2022/0291

Smithy Fold Lodge, Smithy Fold Lane, Wortley, Barnsley, S35 7DA

Conservatory extension to the rear (split level property with conservatory being level with the ground to the rear and at first floor level compared with the internal layout and the front and sides of the dwelling)

PROPOSED REAR ELEVATION

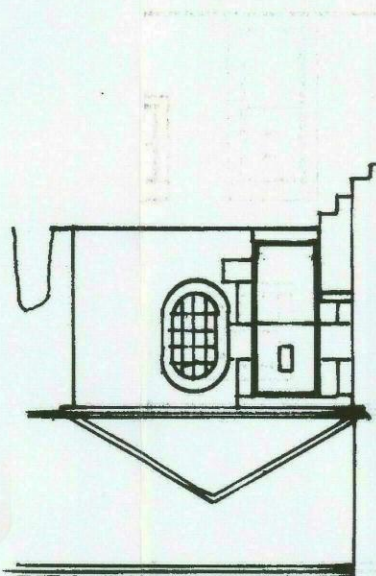
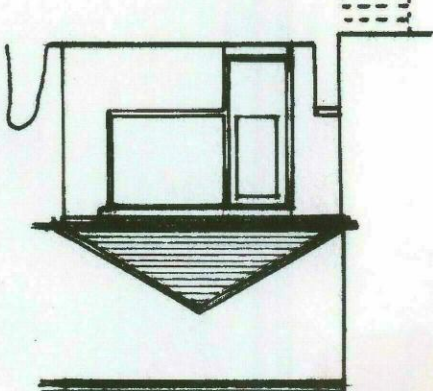
- This objection relates to the proposed boundary of the extension, and specifically to the potential encroachment onto my property. The plans show a view entitled rear elevation, on which the boundary wall can be seen to the right. The location of the boundary wall in this part of the plan appears to be correct.

- As can be seen in the drawing the right-hand part of the applicant's building at this juncture is curved in as had to be the case due to its proximity to the boundary wall. The view entitled proposed rear elevation is therefore incorrect.

- Although it appears to show the boundary wall in the same position, it does not account for the fact that it is then nearly 5 metres away from the original building and would therefore be approximately 1 metre onto my land. In which case, the applicant's extension would lie on top of the footprint of the current boundary wall and overshoot significantly beyond.

- To correct the intrusion of the boundary wall and of my land by the applicant, the proposal would need to be adjusted to follow the angle of the curve on the applicant's building in situ at the present time, or for the building itself to taper, neither of which are objected to.

The objection raised issues relating to trespassing and the boundary between the host dwelling and Smithy Fold Farm. The applicant has signed certificate A on the application form therefore implying that they own all the land within the application site. An informative will be attached to the decision stating that the granting of planning permission does not in any way infer that consent of the landowner is given.

Therefore, the consent of all relevant landowners is required before proceeding with any development. If it should transpire that the applicant does not own any of the land included in this consent, then it is the responsibility of the applicant to seek all necessary consents and approvals of the landowner.

SITE PLAN 1/1250.

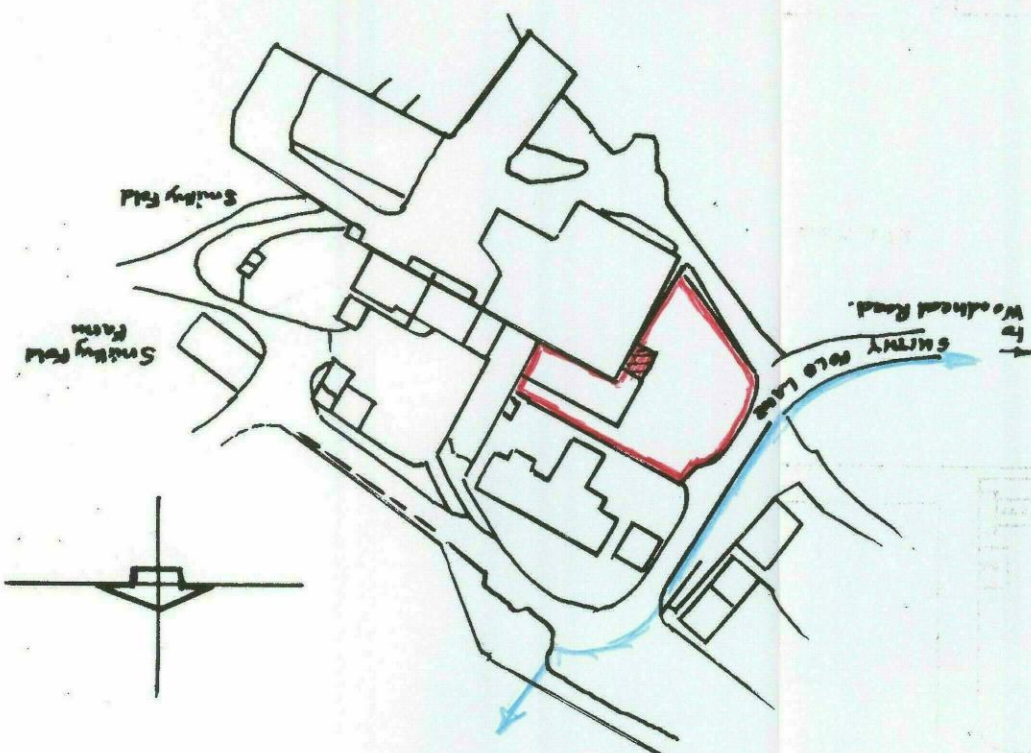
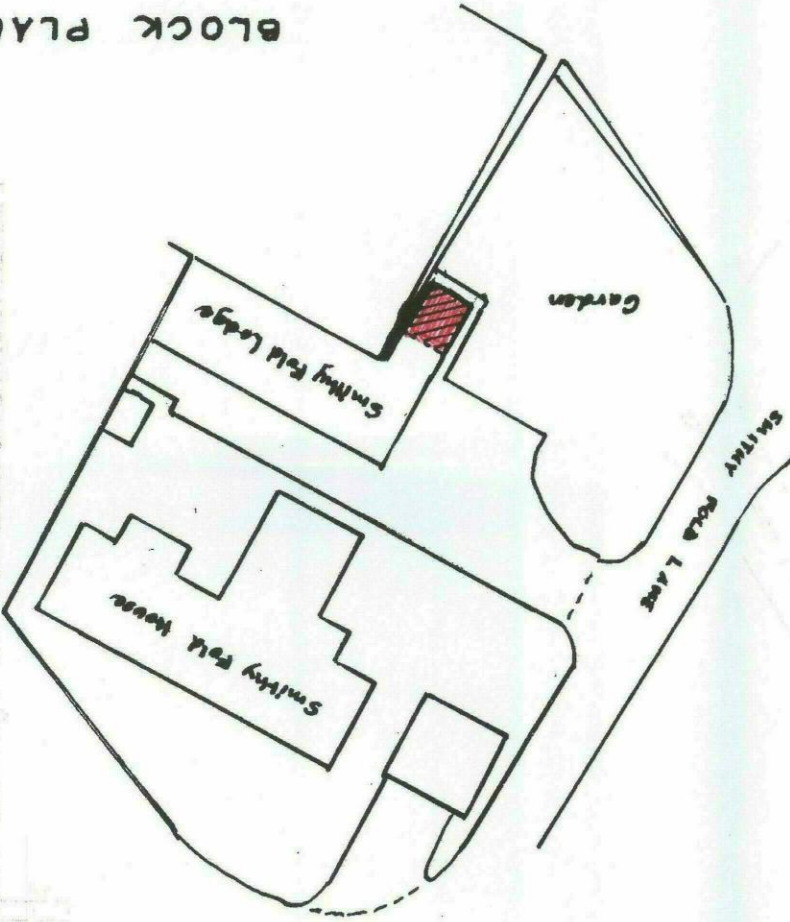
- The boundary wall does not run parallel to the applicant's property, it tapers towards the property, thereby widening the gap between the buildings and the boundary wall itself, the further the distance from the applicant's building. The plans entitled Block Plan and Site Plan do not contain sufficient detail to address the issues noted above. They do not demonstrate the intrusion which would take place onto property that the applicant does not own.
